CITY OF ALBUQUERQUE

PLANNING DEPARTMENT – Development Review Services

June 10, 2014

**RE: Sunset Subdivision
Drainage Calculations for Reconfigured Lots
Engineer's Stamp Date 5-6-2014 (File: K12D025)**

LOT 30-P1
 SUNSET FARM/ PUESTA DEL SOL
 SUBDIVISION
 309 LUIS SANCHEZ PLACE SW
 AREA=5469 SF

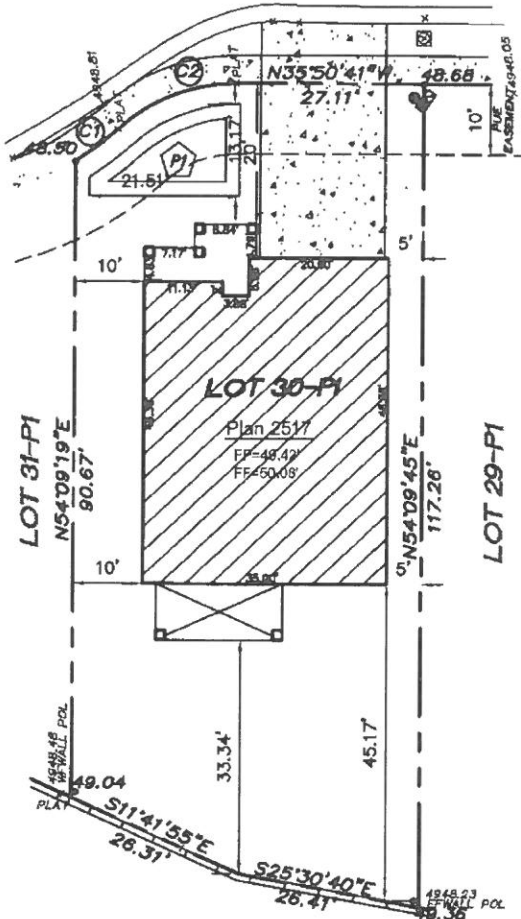
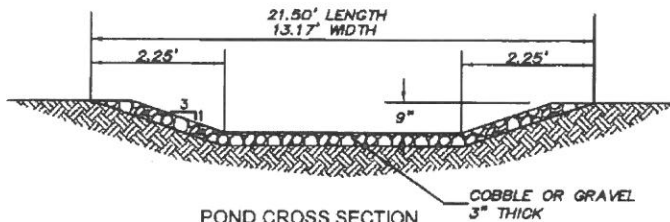
1. Are calculations solely for Lot-30-P1, or for all 10 lots listed on page 1?
2. Total allowable impervious area is based on No. of original lots rather than actual area of new lot. This method is not acceptable because it assumes that the new lot lines encompass the original lot lines. While this is true for Lot 30-P1 and the 2 adjacent lots, it is not necessarily true for the other lots listed on page 1. Based on the conditions listed in the Sunset Farm Subdivision Drainage Report (1998) the calculation should show that the impervious area on the new lot does not exceed 45% of the lot size, only using the area of Lot-30-P1, and not the impervious areas of the other lots.

3. Condition 1 of Sunset Farm Subdivision Drainage Report (1998) states that the site must be flat and/or graded flat, therefore no ponding is acceptable.

4. Condition 5 of Sunset Farm Subdivision Drainage Report (1998) states that the flow between the front yard and the back yard cannot be obstructed, and the storm water must be allowed to equalize to the same level. Therefore, ponding is also not allowed per this condition.
